From: Brendan Hoskins <BHoskins@jbaurban.com.au>
Sent: Friday, 5 August 2016 6:33 PM
To: Matthew Rosel
Cc: Brendon Roberts; Mason, Michelle; Alexis Cella
Subject: SE Plot clarifications/additional information
Attachments: Further Response Table.pdf; Attachment B - Acoustic Letter.pdf; Attachment C - Landscape Design Letter.pdf; Attachment A - Amended FJMT Drawings.zip

SICEEP, SOUTH EAST PLOT (SSDA9) – FURTHER RESPONSE TABLE

RE: SICEEP SOUTH EAST PLOT – ACOUSTIC CLARIFICATION

RE: RESPONSE TO DEPARTMENT DA SUBMISSION 2 – NOISE IMPACTS

2B1B ADAPT
72 m201 PLAN Pre SE3 L03-05.08
1:50

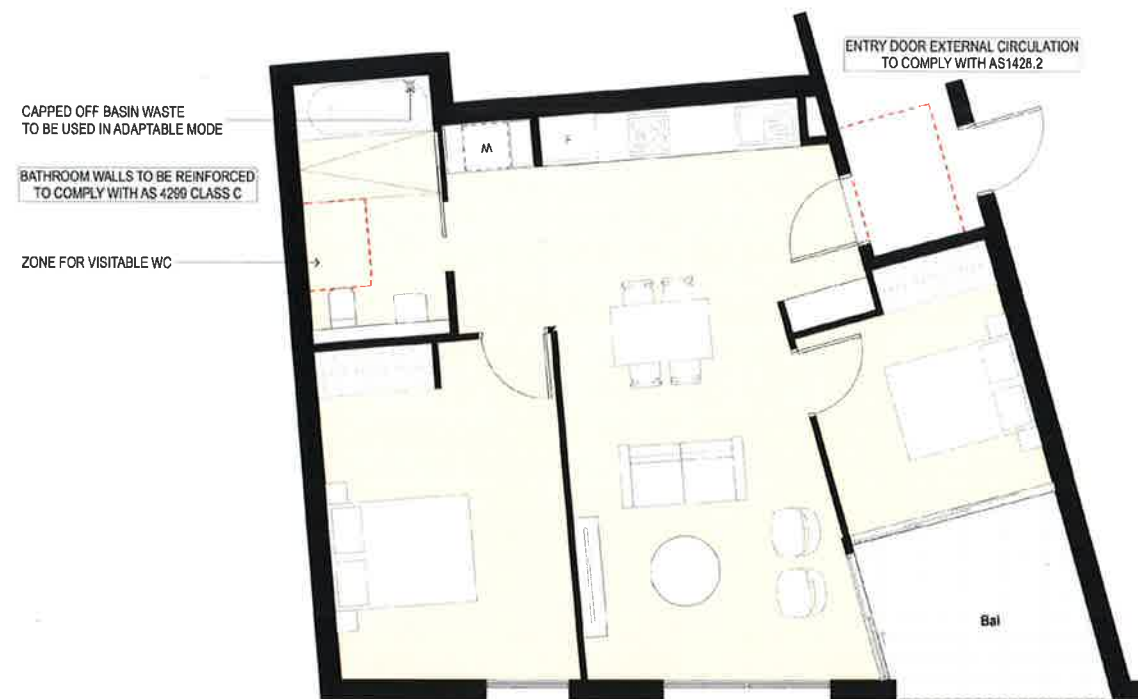
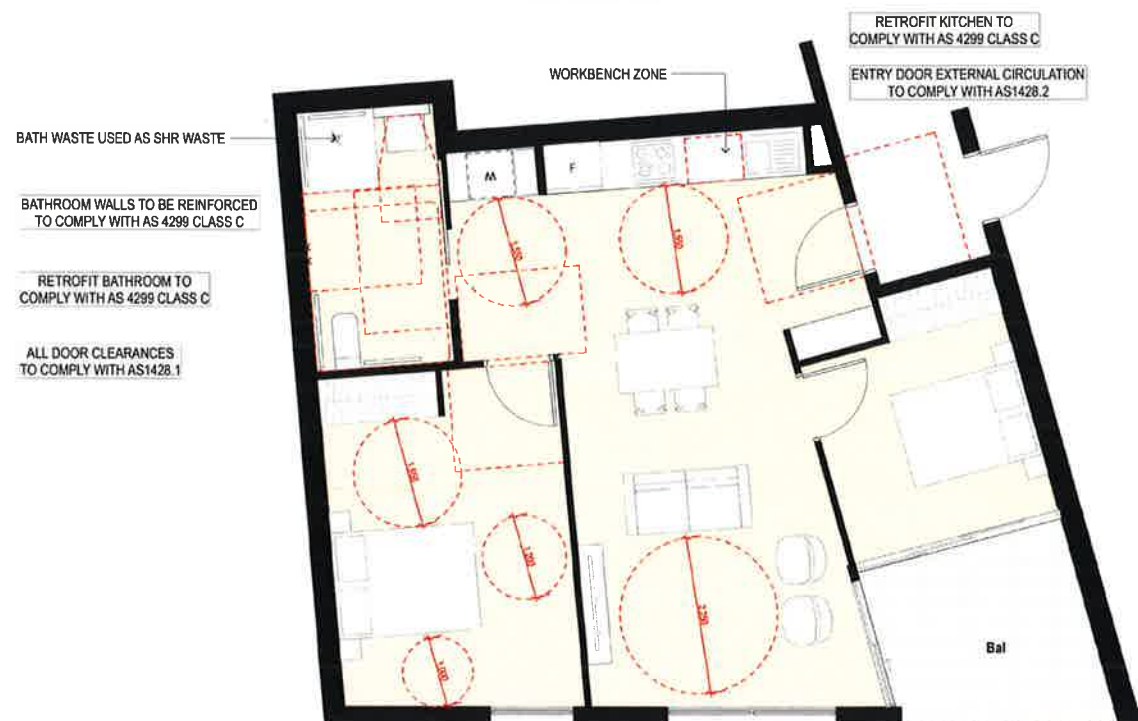
Confirm the number of apartments that comply with the 4Q Universal Design Standards (UDS) of the ADG, and justification of any exceptions to the UDS.	78 apartments (20% of apartments in the South East Plot) achieve the Liveable Housing Guideline's silver level commitments with the exception of one element: - 5a.ii of the Liveable Housing Guide – distance between the bathroom door and toilet plan. The bathroom design within these apartments is generally consistent with other similar apartment types, ensuring efficiencies in construction and apartment planning throughout the buildings. The variation sought in the width of these bathrooms compared to the silver level commitments ranges from 233mm to 394mm. This represents an indiscernible amount of space within the overall apartment.

Key Issue	Response
	Overall, in light of the provision of adaptable apartments within the South East Plot, and other approved plots, as well as the 78 apartments which largely achieve the silver level commitments, with the exception of one variation, the proposal is considered to achieve Objective 4Q-1 of the ADG in that it provides universal design features in apartments which promotes flexible housing for all community members.
Confirm whether Drawing R2008 10 'Without Operable Screen' represents an option not to provide/install the operable screens.	Drawing R2008 has been provided to illustrate the proportion of glazed and solid elements behind the proposed bi-fold screens. This design is not presented as an option, rather the drawings has been provided for information purposes.
Confirm the predicated construction jobs.	Specifically, for the South East Plot, there will be a total of 450 construction jobs and 84 operational jobs.
